WEST SUSSEX COUNTY COUNCIL CONSULTATION

TO:	Arun District Council FAO: Simon Davis
FROM:	WSCC - Highways Authority
DATE:	9 April 2020
LOCATION:	Land To South Of Barnside Hook Lane Aldingbourne PO20 3TE
SUBJECT:	AL/28/20/DOC Approval of details reserved by condition imposed under ref APP/C3810/W/16/3155330 (AL/8/16/OUT) relating to Condition Nos 11 - visibility splay, 12 - fire hydrant, 13 - foul drainage, 14 - surface water drainage and 18 - external lighting.
DATE OF SITE VISIT:	n/a
RECOMMENDATION:	Advice
S106 CONTRIBUTION TOTAL:	n/a / £ See below for breakdown.

P4	11.09.19	AMENDED TO SUIT WSSC COMMENTS.	PJM
P3	15.07.19	NOTE TO TELEPHONE POLE ADDED.	JMB
P2	01.07.19	EXTENT OF WORKS AMENDED.	JMB
P1	14.06.19	PRELIMINARY ISSUE FOR COMMENT	JMB
Revision	Date	Description	By

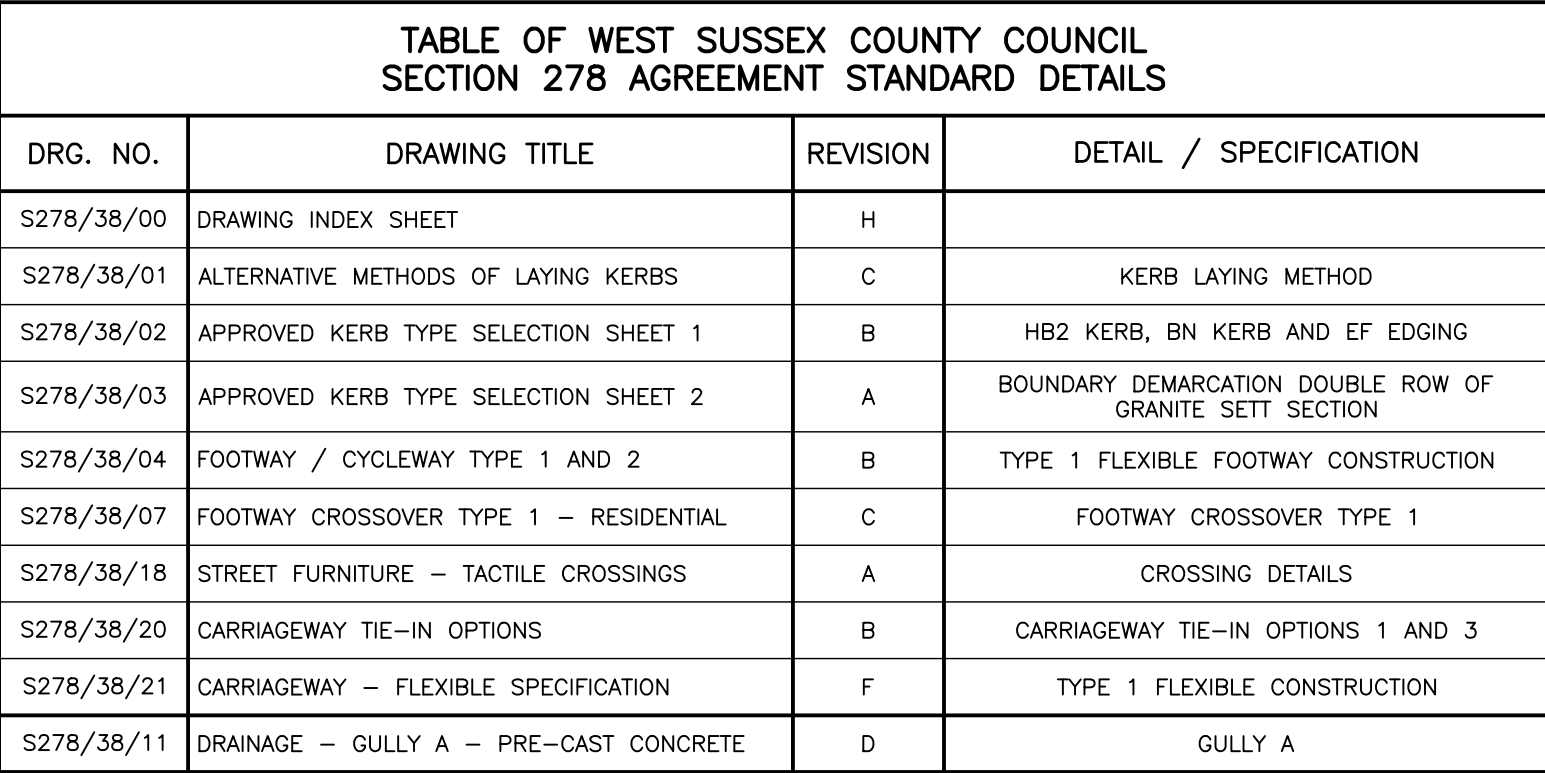
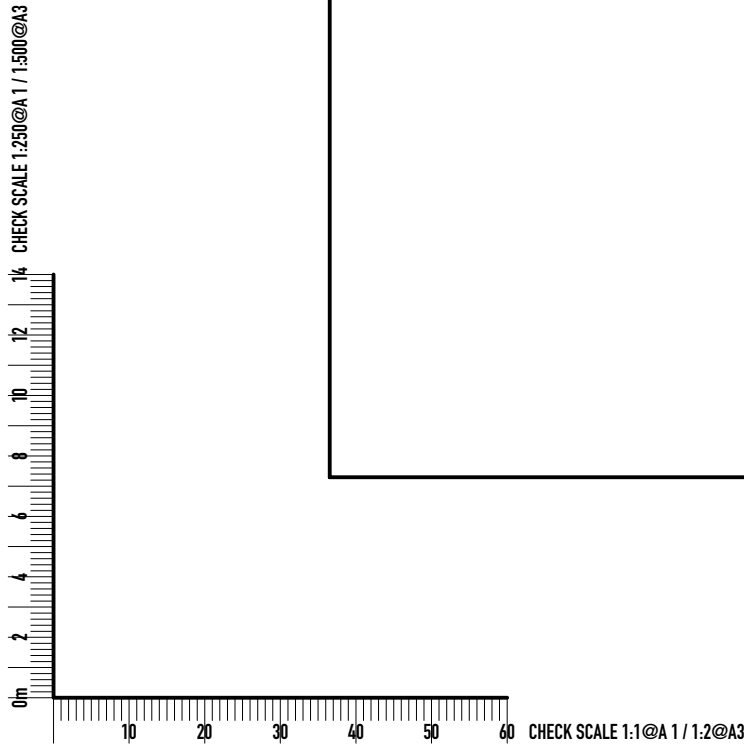
Condition 11- The agreed visibility splays have been subject to a Section 278 Agreement with the LHA. Drawing AAL 156-520 P4 demonstrates visibility splays previously agreed with the LHA. On that basis the LHA would advise that Condition 11 can be discharged.
